DOC22/160370-17

**EPA Advice on Submissions Report for proposed Jalco Manufacturing Facility,
Horsley Park (SSD 21190804)**

Attachment A. Comments on SSD21190804 RTS, Appendix E, HORSLEY LOGISTICS PARK Lot 201 - Warehouse 1, Air Quality Impact Assessment, SLR Ref No: 610.19360-R04-v3.0, (25 February 2022

Figure 14 Odour Impacts

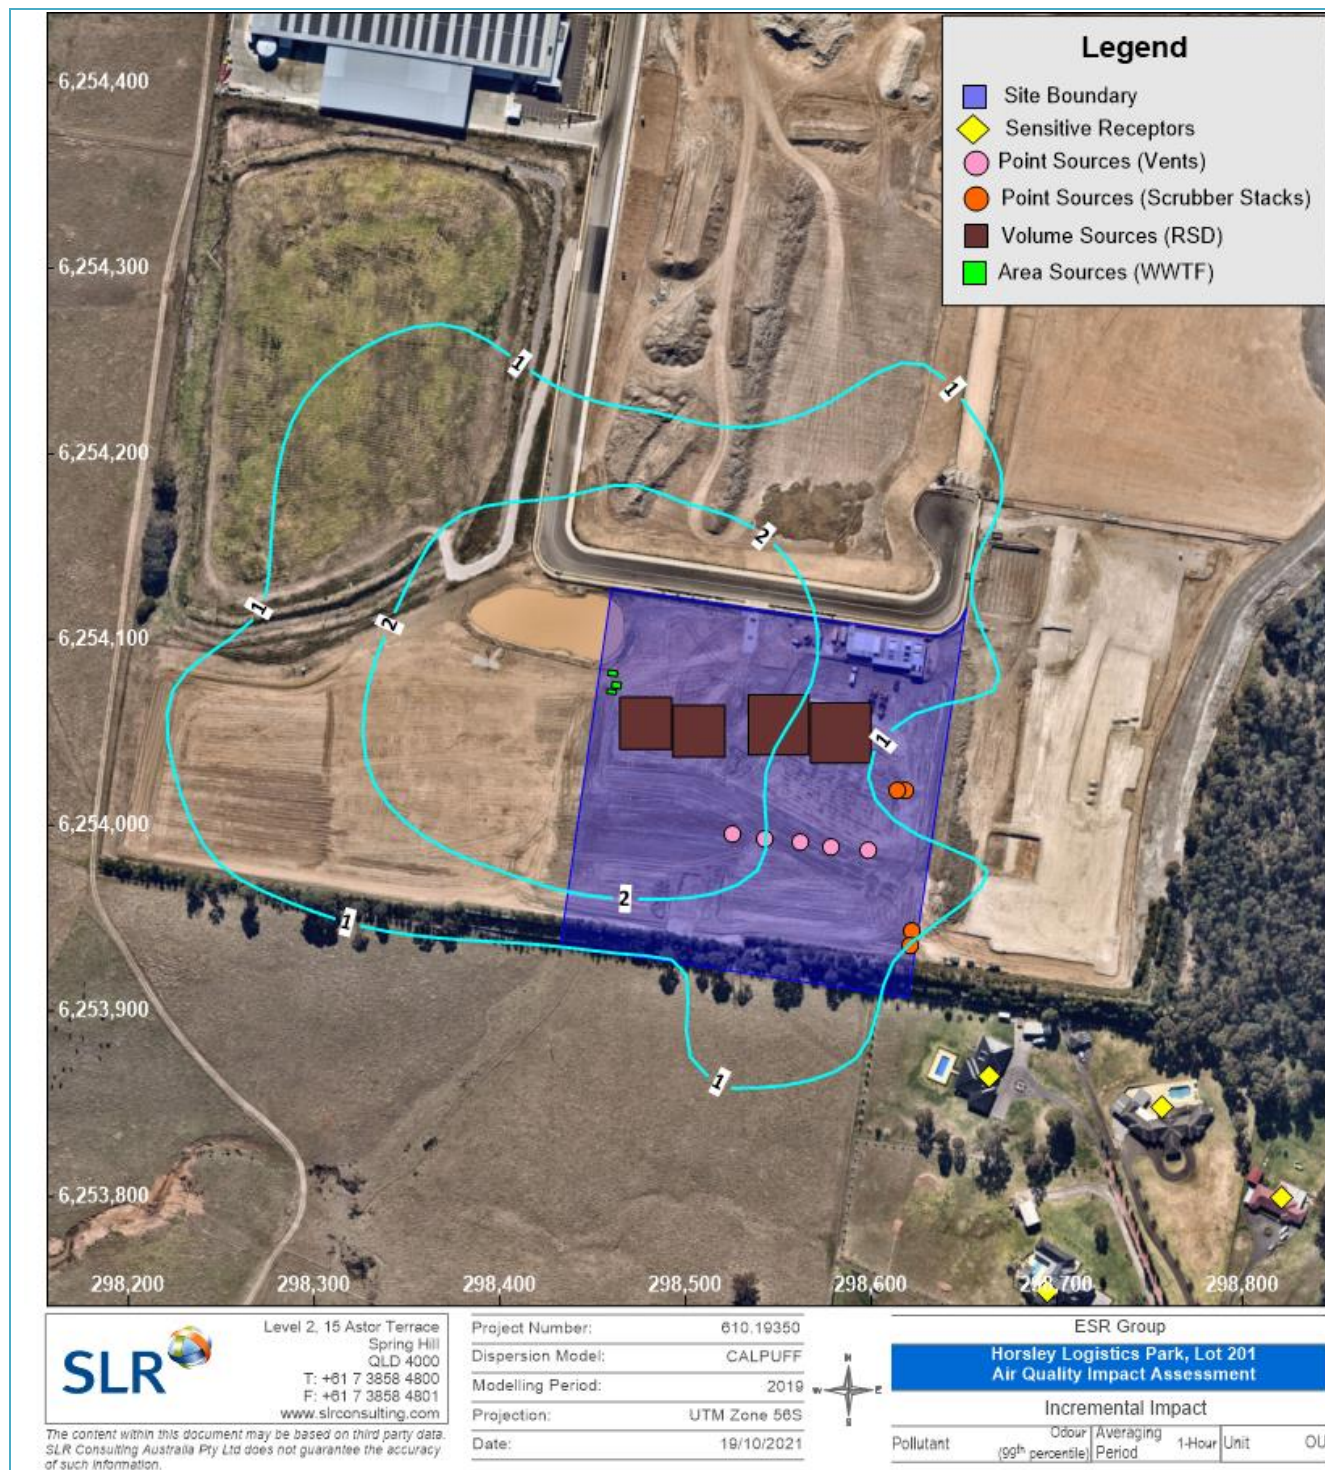
The results of the revised AQIA indicate that the project could impact neighbouring industrial receptors. Odour contour plots show predicted odour impacts of 5 OU occurring at the adjacent industrial premises (C1). This is above the 2OU criteria adopted for the assessment. The revised AQIA speculates that the predicted impacts are influenced by sources located close to the Eastern boundary of the premises such as the WWTP. However, a source apportionment analysis has not been performed.

The revised AQIA has reported the predicted impacts at the neighbouring premises (C1) as the average across the entire commercial site. This is not considered appropriate as it ignores the high concentrations predicted to occur at the premises.

The EPA recommends additional assessment be undertaken such that the project is demonstrated to comply with EPA's impact assessment criterion. This could include the following:

- **Use a more refined level of assessment.**
- **Adopt additional mitigation measures and/ or controls such as a commitment to enclose the WWTP as assessed in the Response to Submissions, Revised Air Quality Impact Assessment (SLR, 2022)**
- **Redesign the activity/ location of emission sources away from receptors.**
